# Rezoning Transportation Analysis

Petition Number: 2021-125

**Reviewer: Alfred Oyoyo**

Date	Description
09-17-2021	First Review (WLB)
11-22-2021	Second Review (AO)
01-25-2022	Third Review (AO)
02-21-2022	Fourth Review (AO)
03-23-2022	Fifth Review (AO)
04-25-2022	Sixth Review (AO)

RZ-1.0

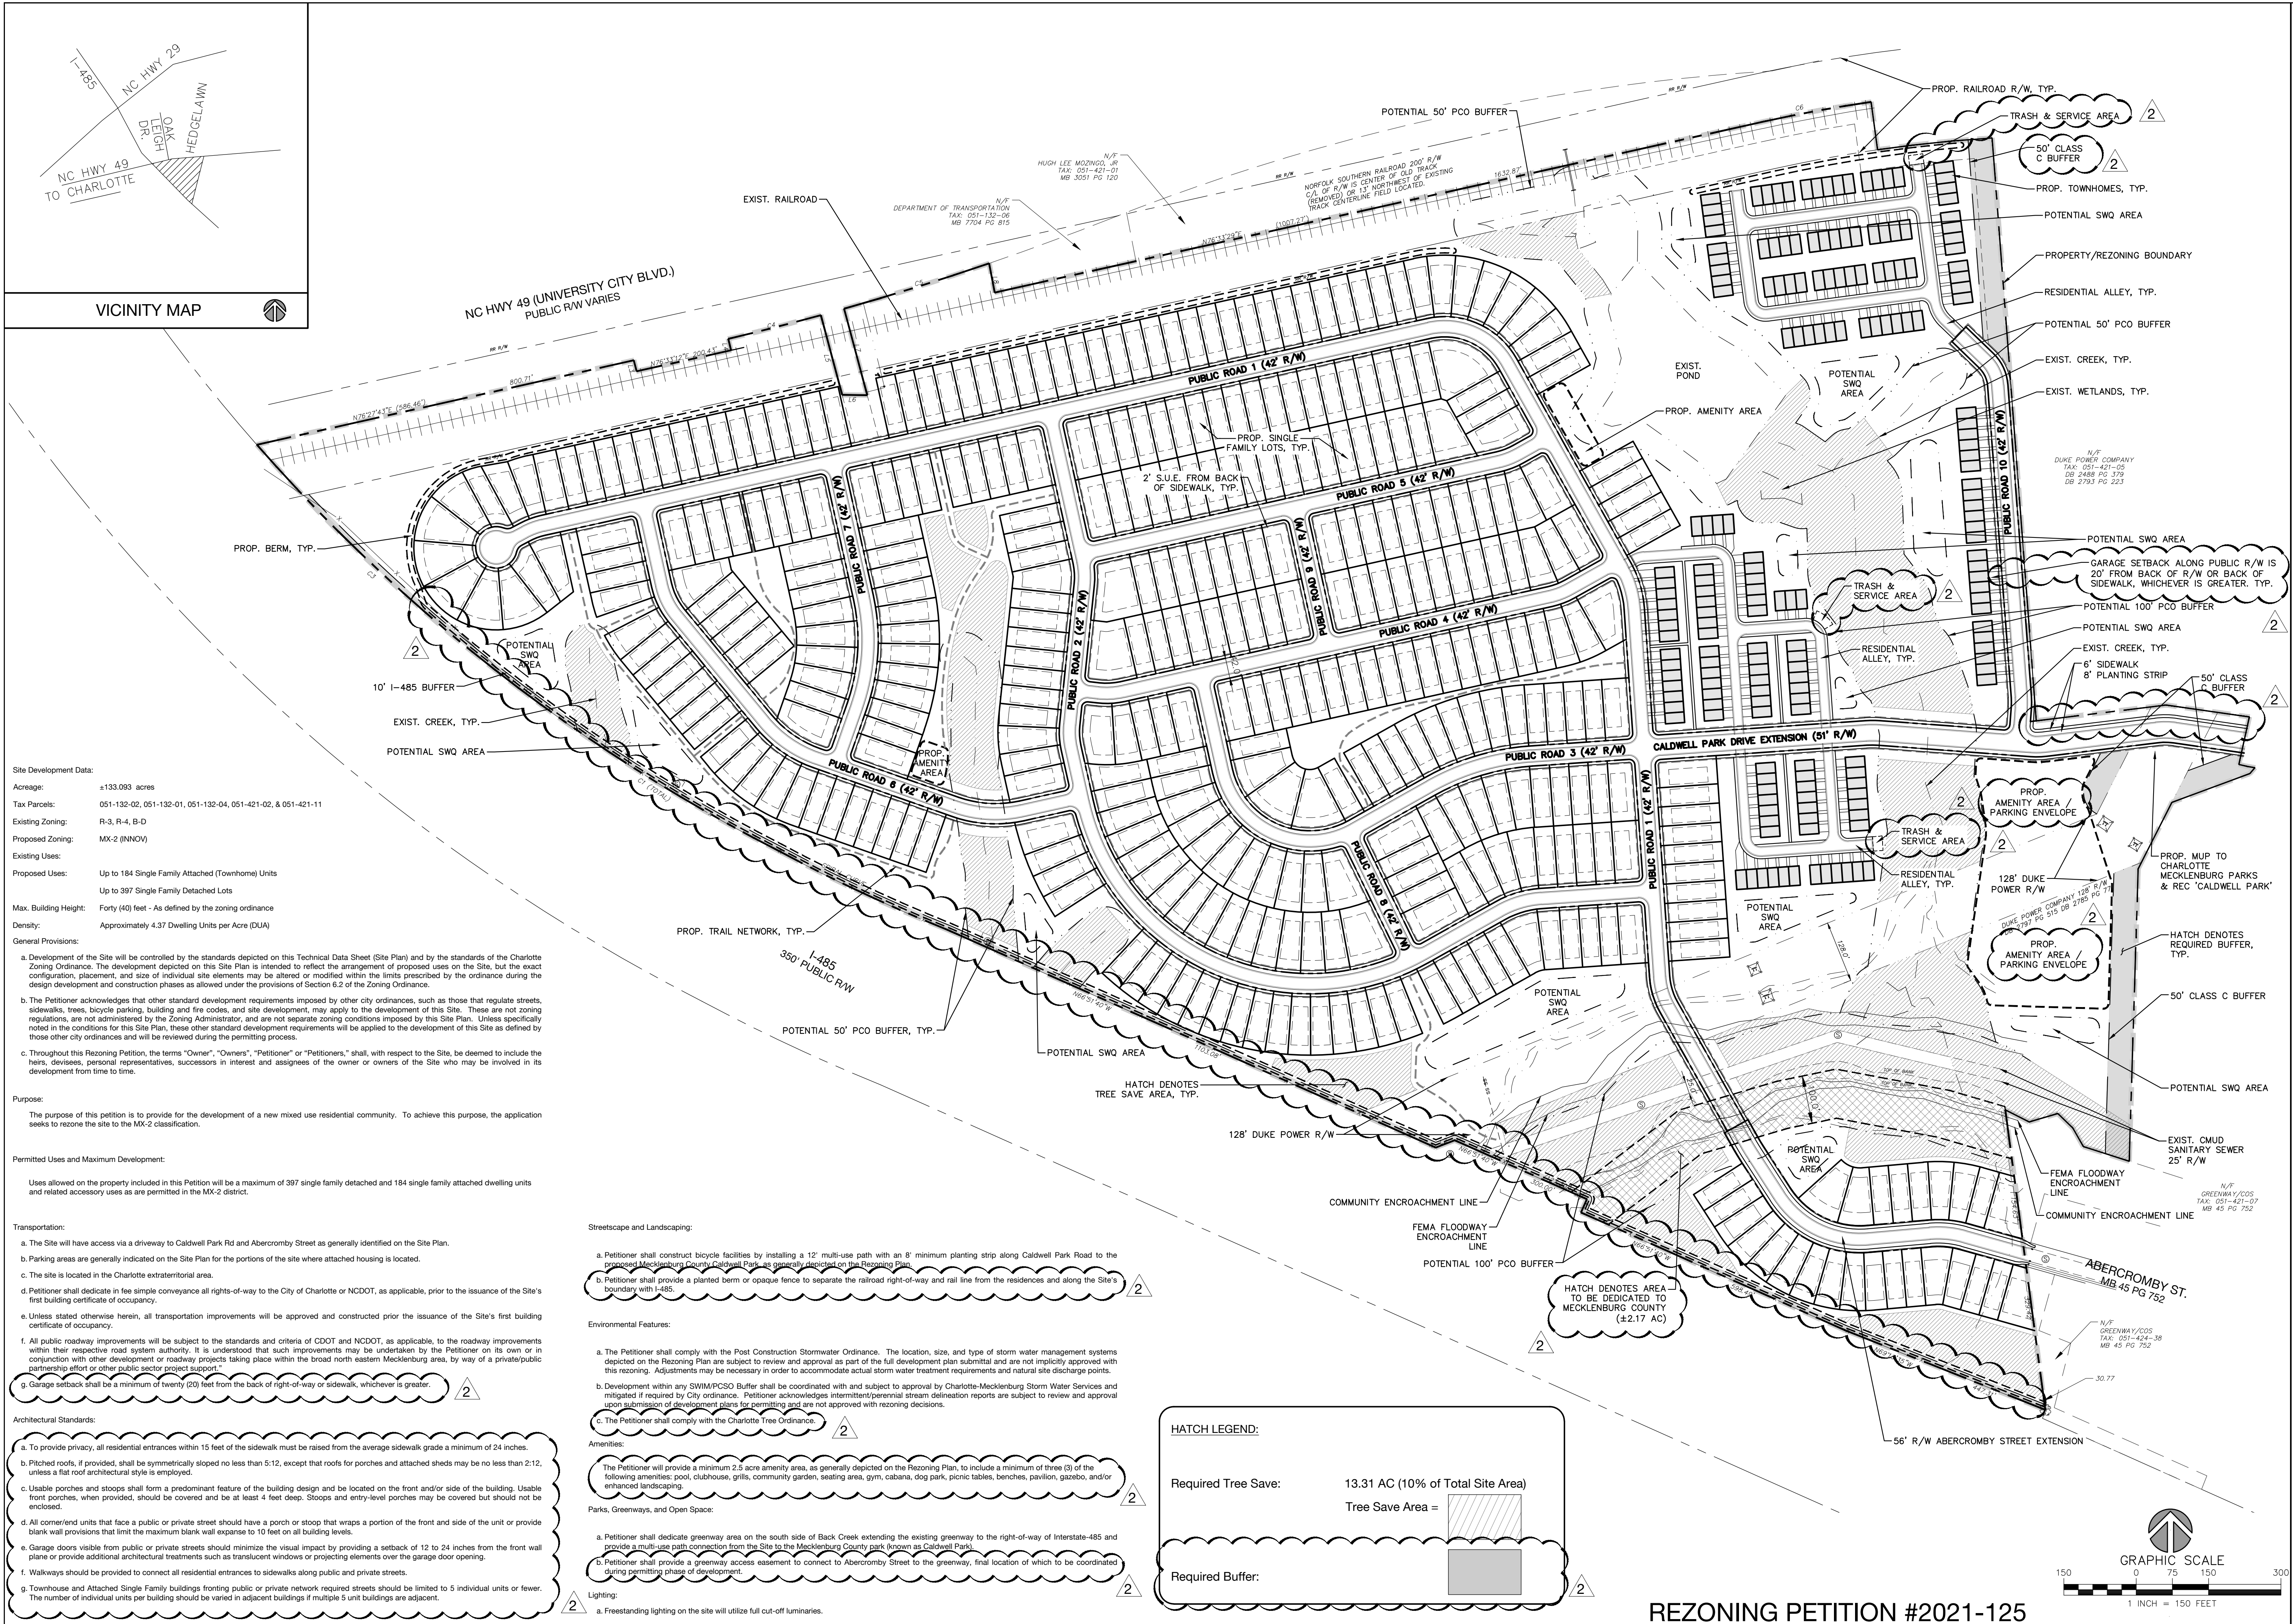
~~**Rescinded (New Site Plan: 1-17-22):** Label and dimension the future curb and gutter from the centerline for each road on the site plan.~~

~~**Rescinded Comment (New Site Plan: 1-17-22):** Show existing University City Blvd and all proposed improvements along University City Blvd on site plan.~~

**RZ-1.0**

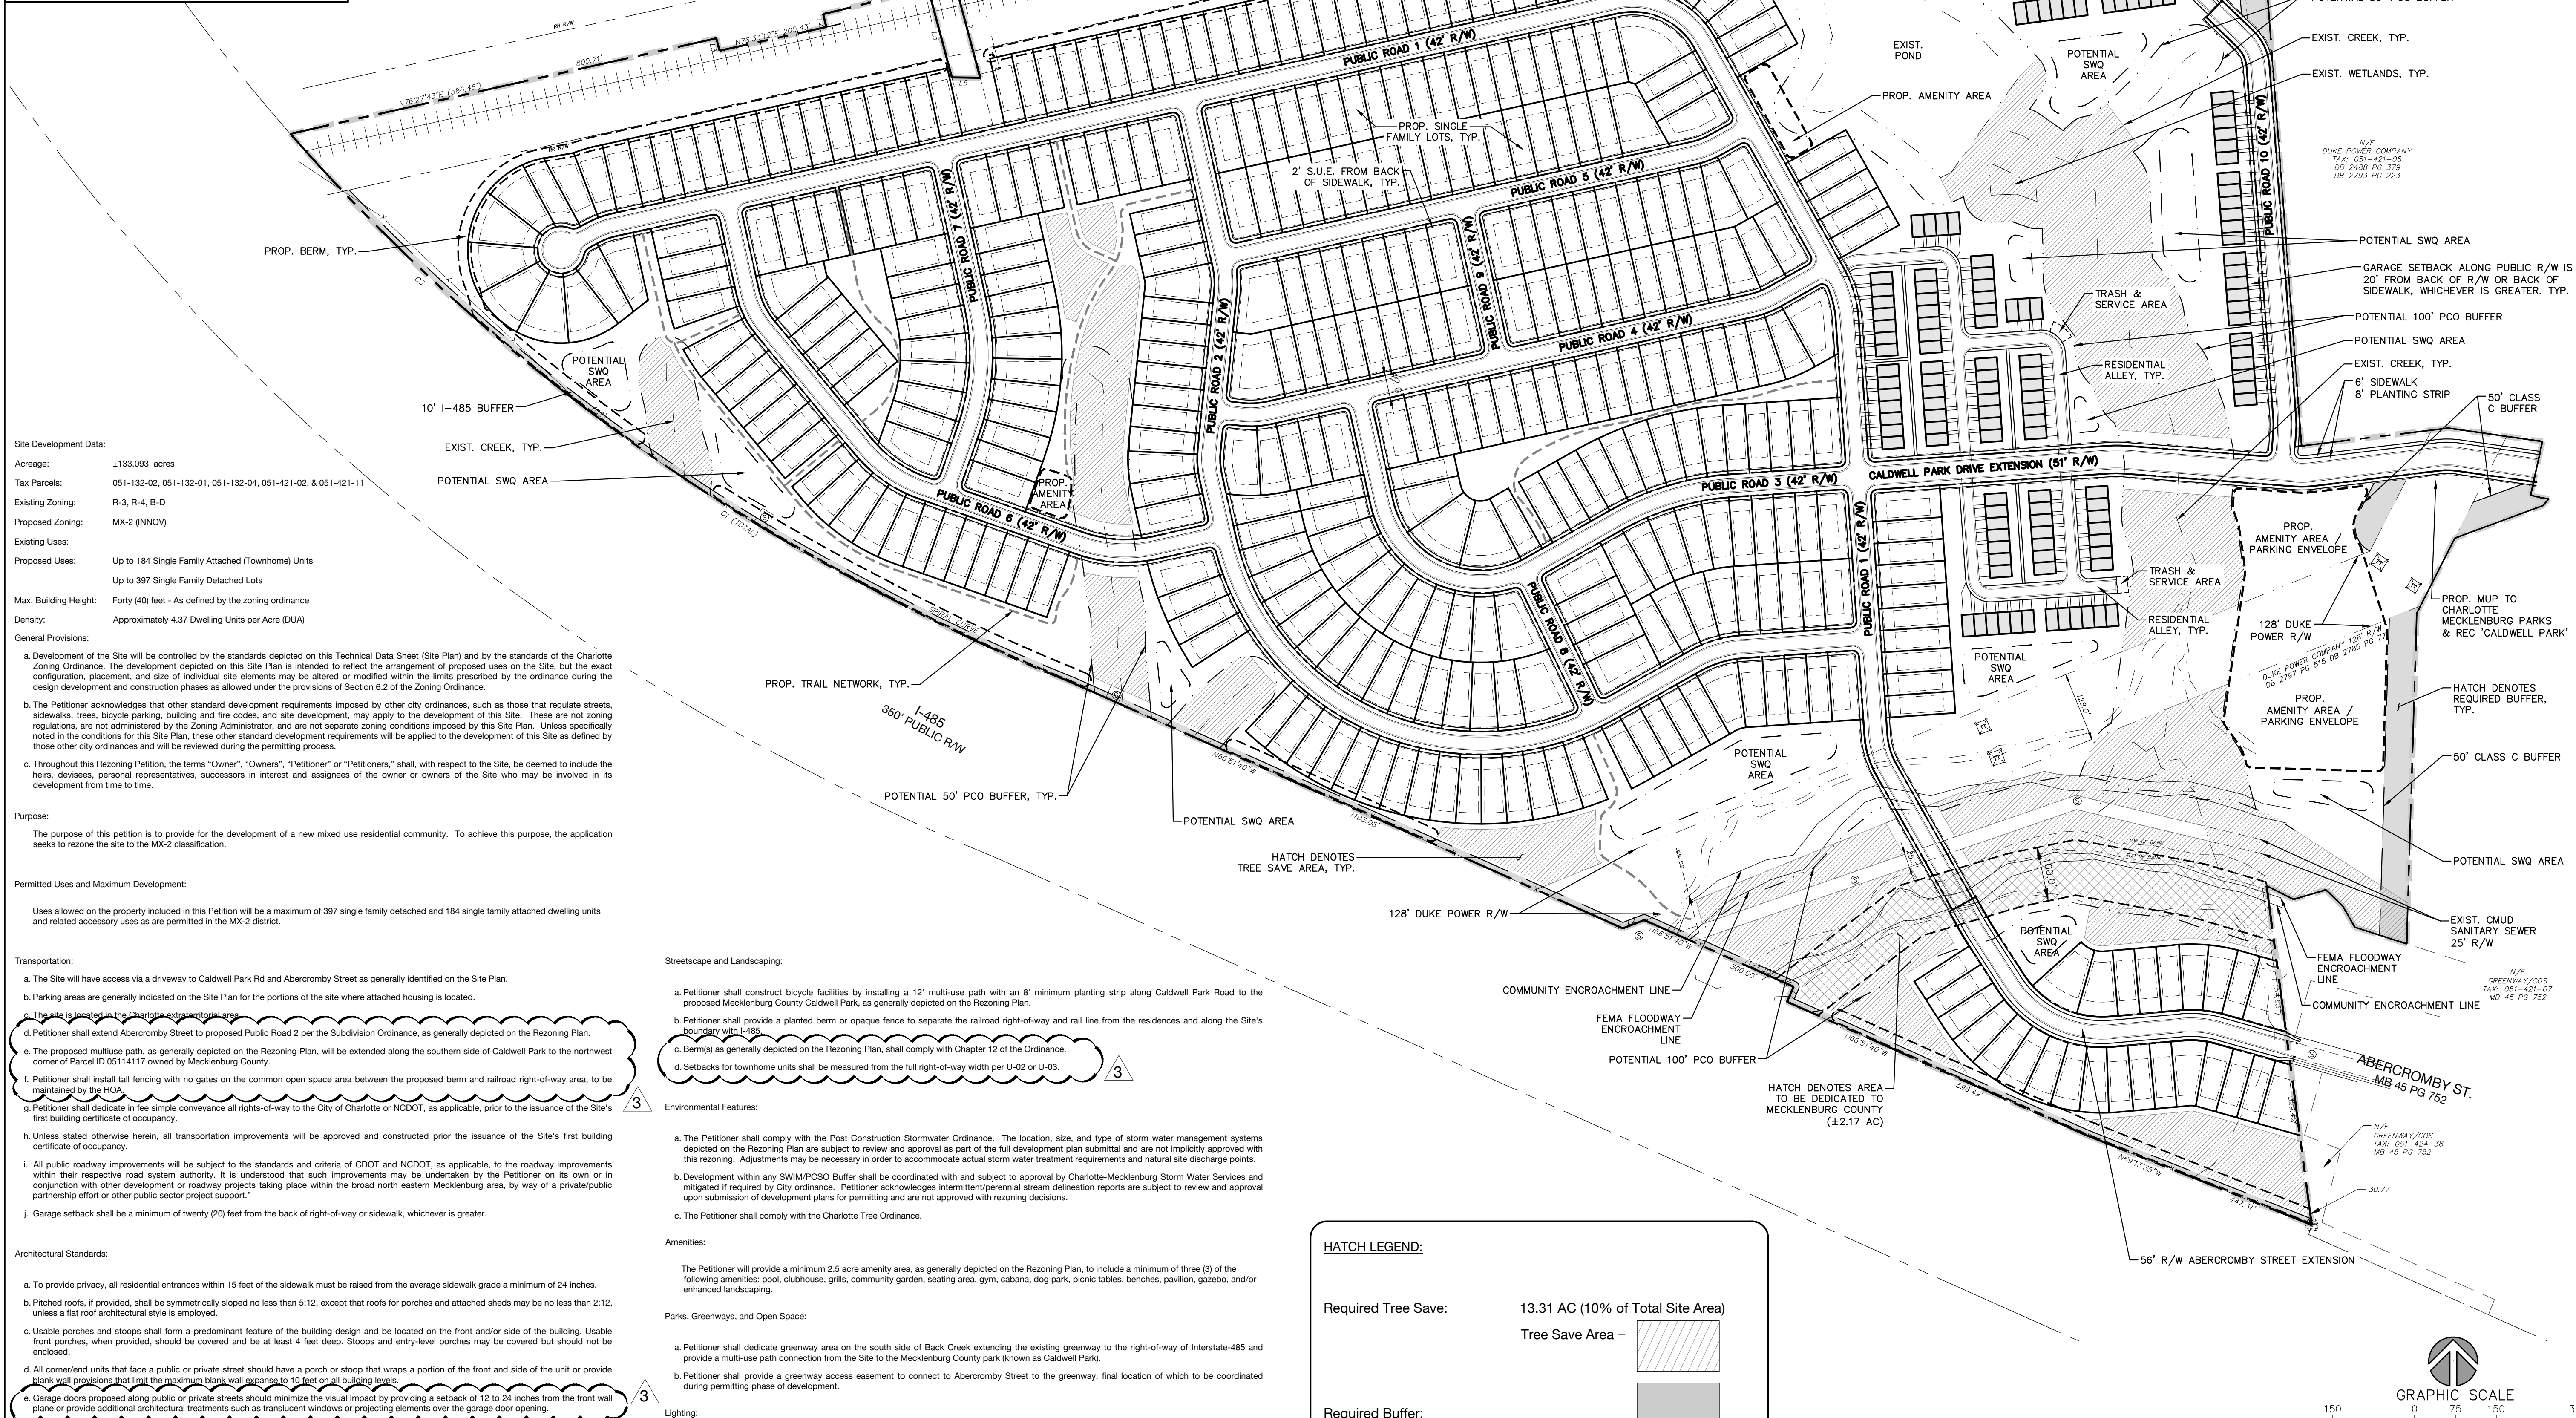
- ~~5. **Resolved (New Site Plan: 2-14-22):** Add conditional note(s) committing to extend Abercromby Street to proposed Public Road 2 per the Subdivision Ordinance.~~

9. ~~**Resolved (New Site Plan: 2-14-22):** Site plan and conditional note(s) revisions are needed to identify exact location and limits of multi-use path along Caldwell Park Road.~~

11. ~~**Resolved (New Site Plan: 2-14-22):** Site plan and conditional note(s) revisions are needed to commit to the construction of noise walls or tall fencing (with no gates) between the railroad right-of-way and the home lots that back to the railroad. The wall/ fencing should be placed within open space to allow for the HOA to maintain it.~~
